Date 22 January 2024  
Our Ref 24/00028/CLP

**Town and Country Planning Act 1990 (As Amended)**  
**79 Rosebery Road, Epsom, Surrey**  
**Lawful Development Certificate - Proposed Use: Widening of existing dropped kerb**

79, Rosebery Road, Epsom, Surrey, KT18 6A - Existing and Proposed Site PlanB

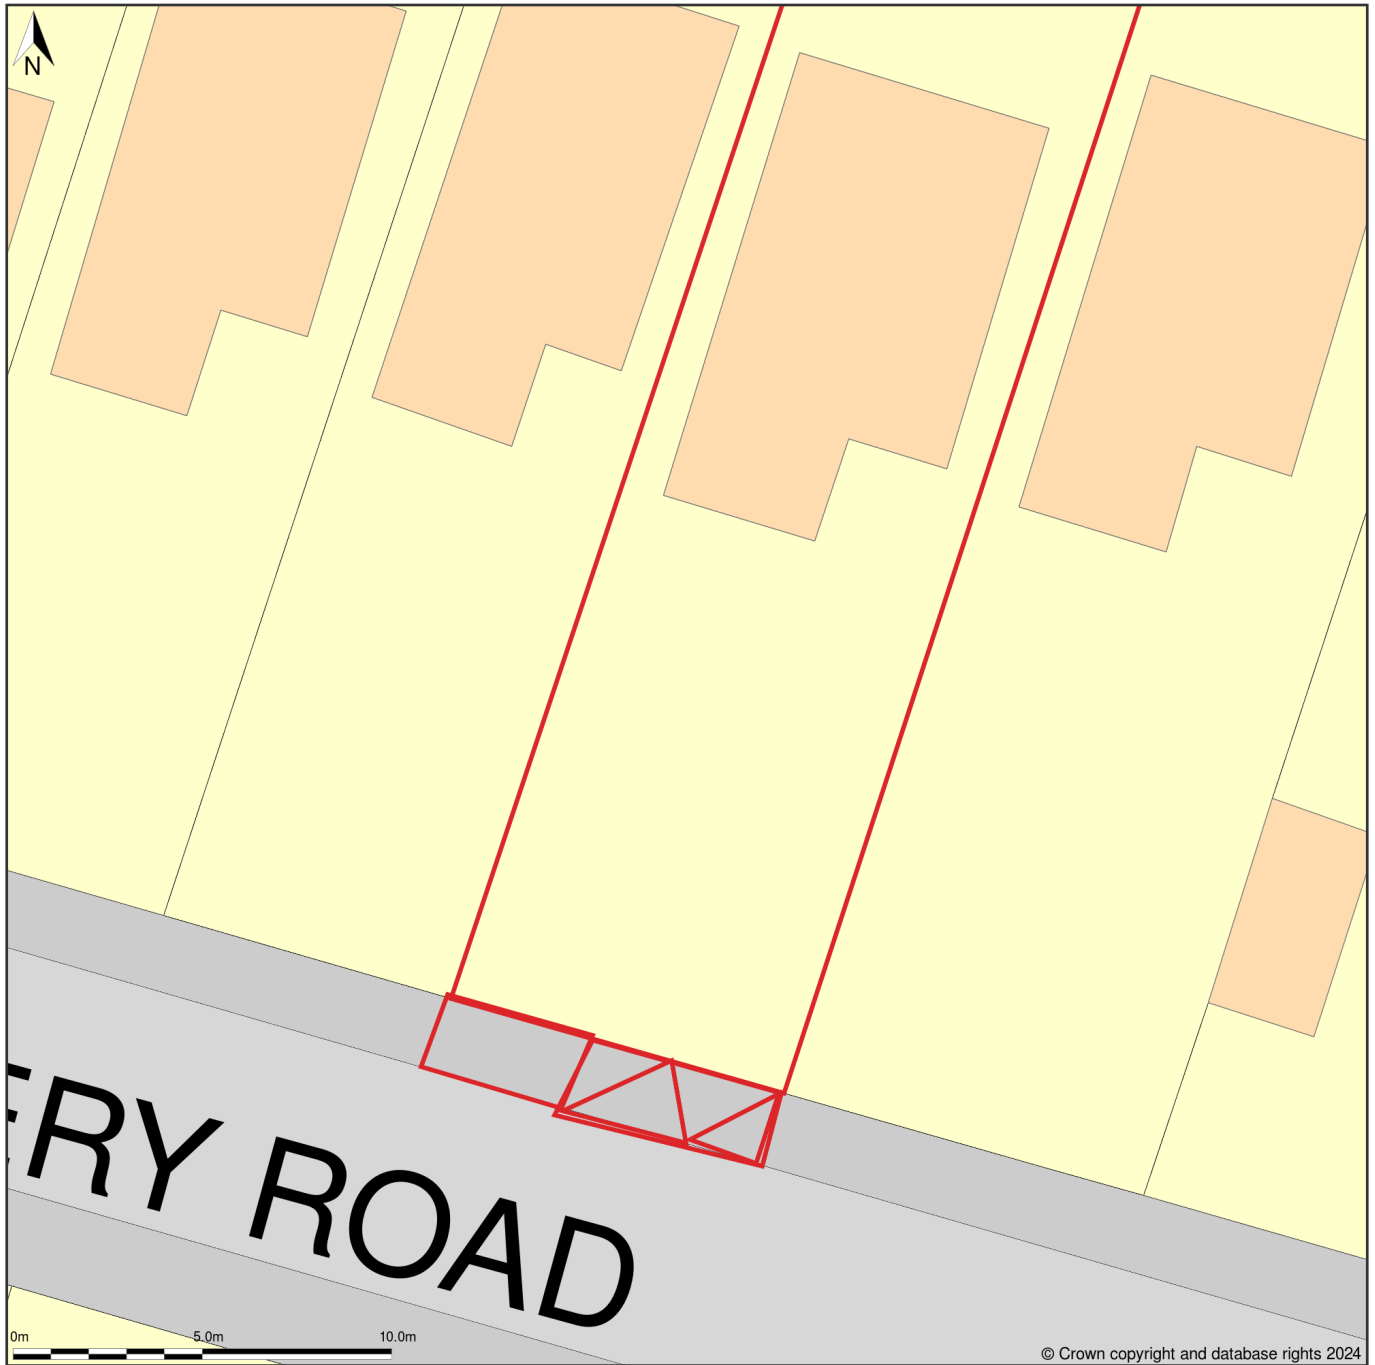
2 EXISTING AND PROPOSED SITE PLAN - Please submit an existing and a proposed Site Plan at a scale of 1:200 or 1:500 showing the proposal clearly differentiating from the existing (e.g. hatched) and its relation to the site boundaries, any other existing buildings on site and the neighbouring properties. The existing site plan is to show the current situation and the proposed plan is to show the proposed situation. Please ensure the plans incorporate the pavement and the dropped kerb.
